From: Simon Davis
Sent: 19 February 2018 17:41
To: Planning.Responses
Subject: FW: Barnett Close AL/8/18/PL

From: Clare Sutton (MHA) [REDACTED]
Sent: 19 February 2018 12:41
To: Simon Davis
Cc: Mark Coates
Subject: RE: Barnett Close

From: Simon Davis [mailto:Simon.Davis@arun.gov.uk]
Sent: 19 February 2018 10:15
To: Clare Sutton (MHA) [REDACTED]
Cc: Mark Coates <Mark.Coates@arun.gov.uk>
Subject: Barnett Close

location plan &
proposed site plan

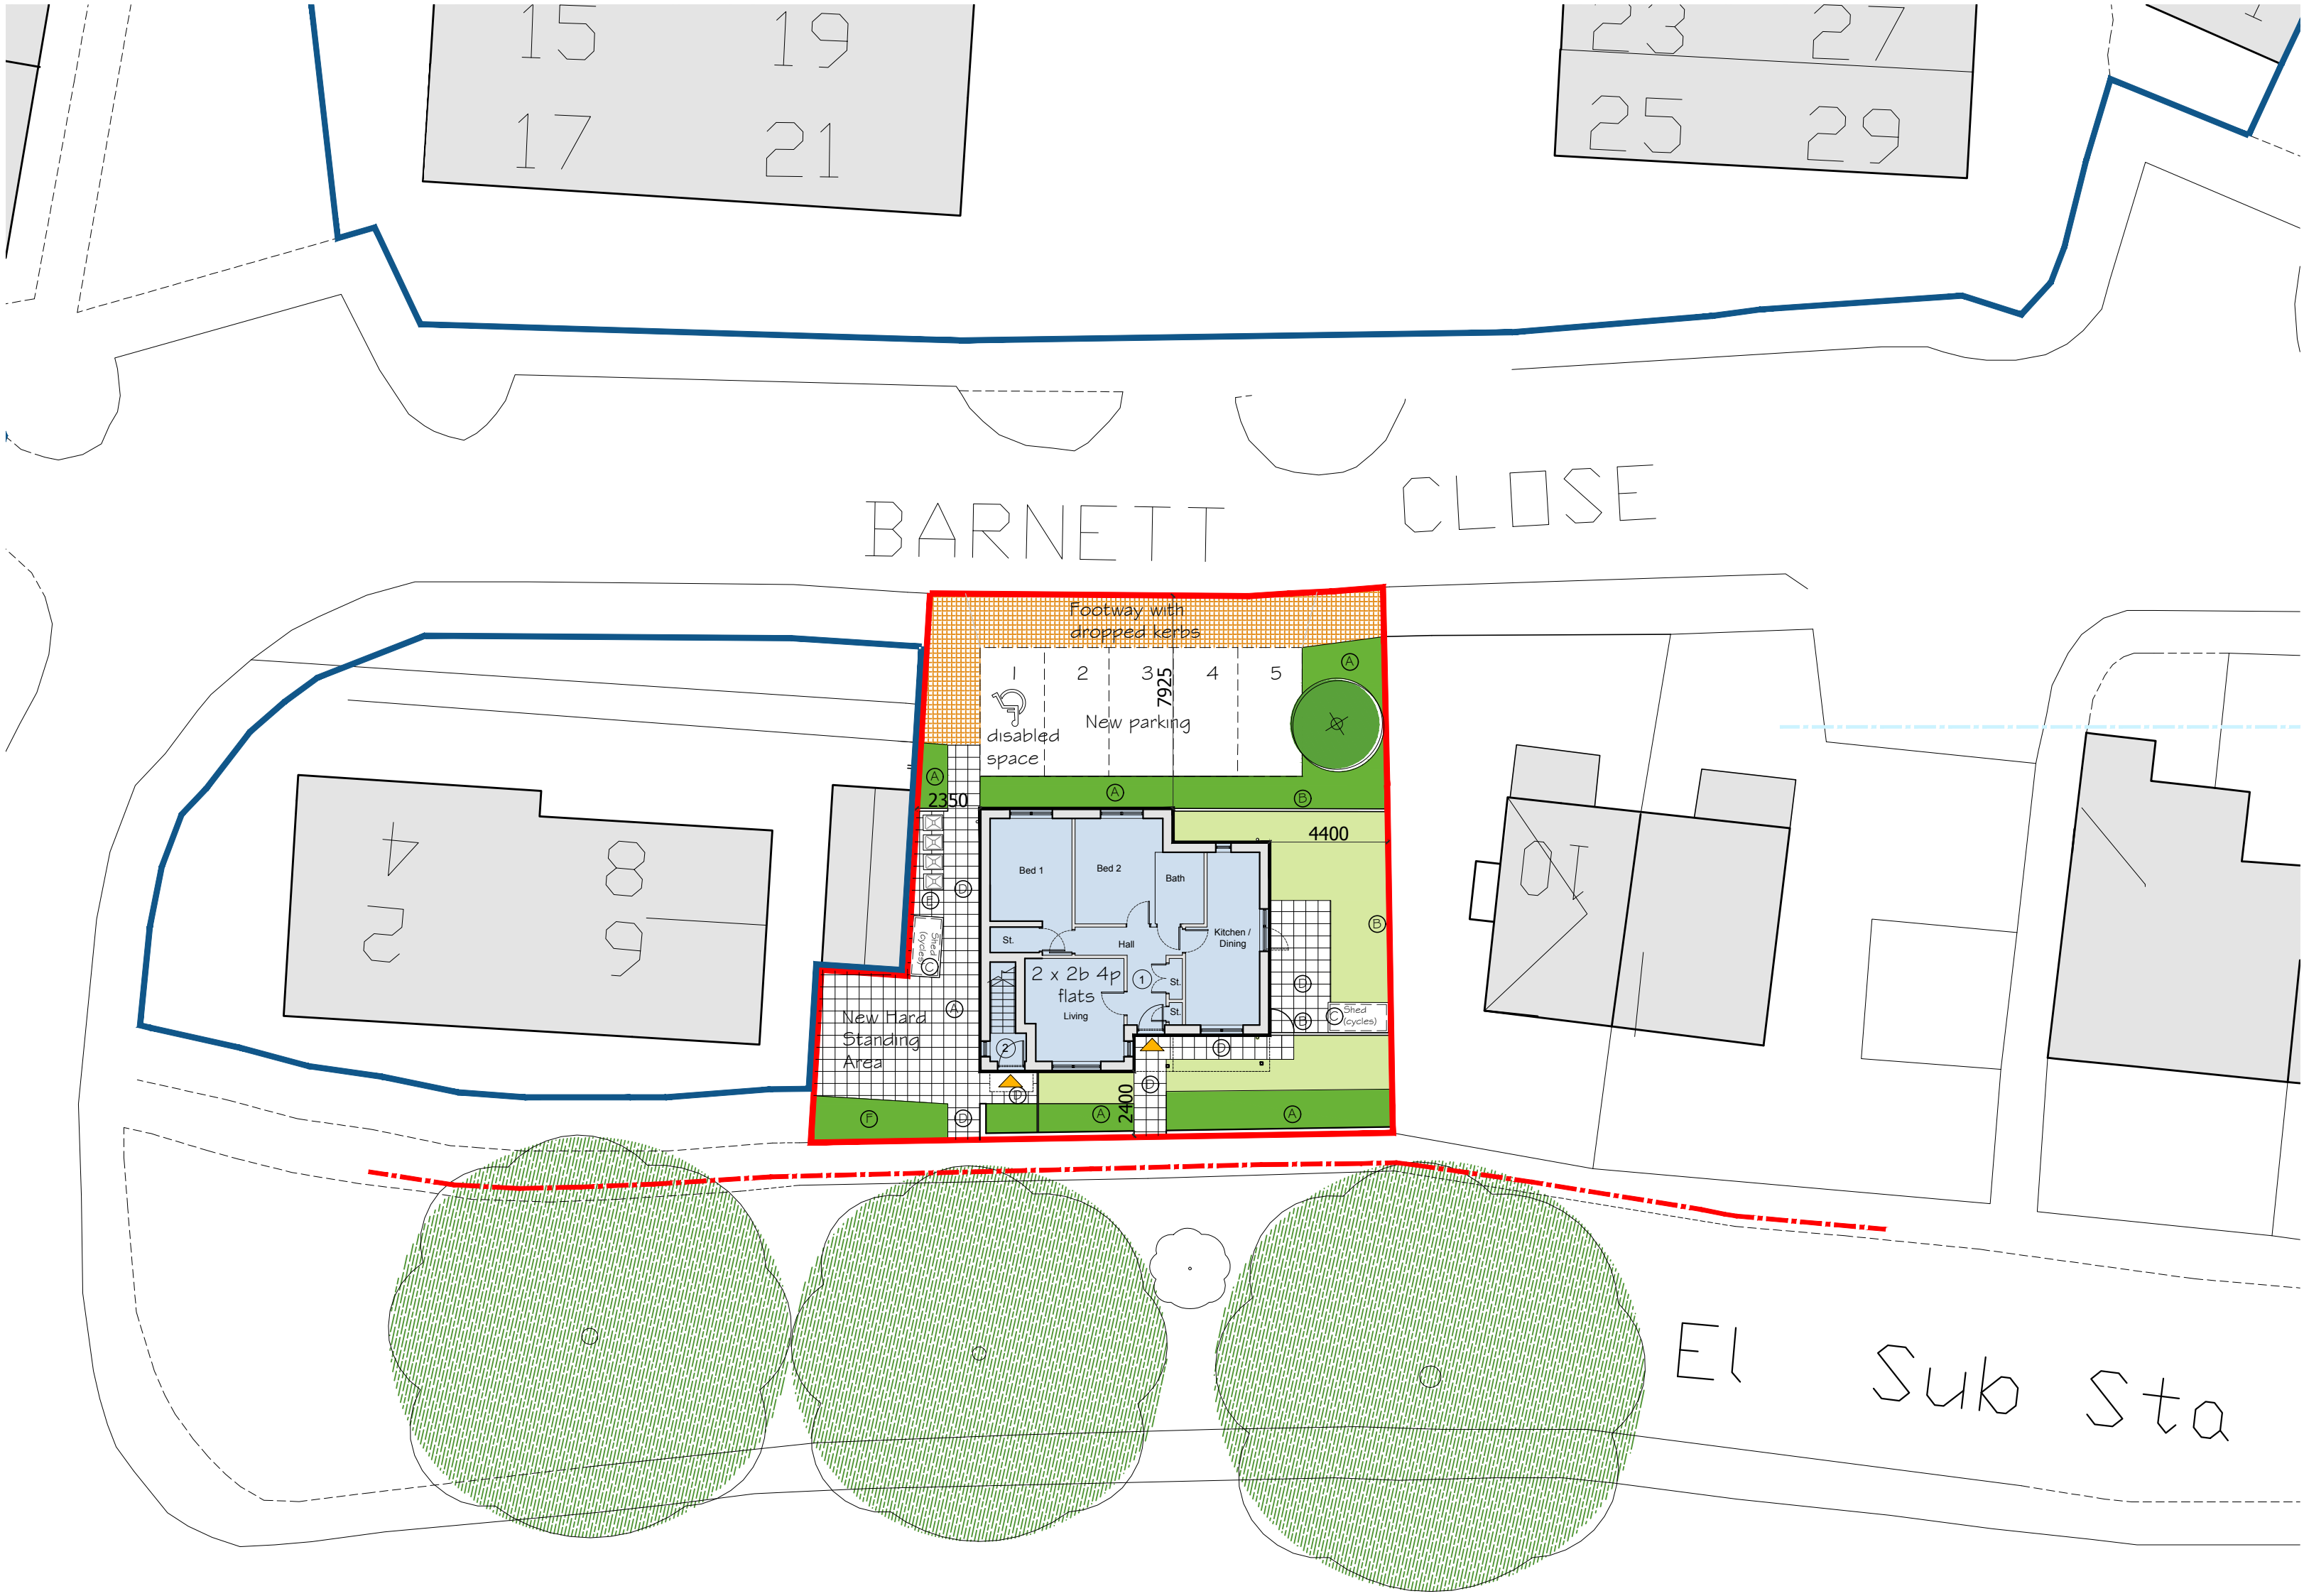
Please see Highway comments, in particular the comment about the disabled parking.

Please find attached a revised drawing with the disabled parking space changed to a standard parking space. I had intended that the 1200mm footpath to the side and rear of the space and with level paving would provide the access required for a disabled space but it is easier to change the drawing than argue the point.
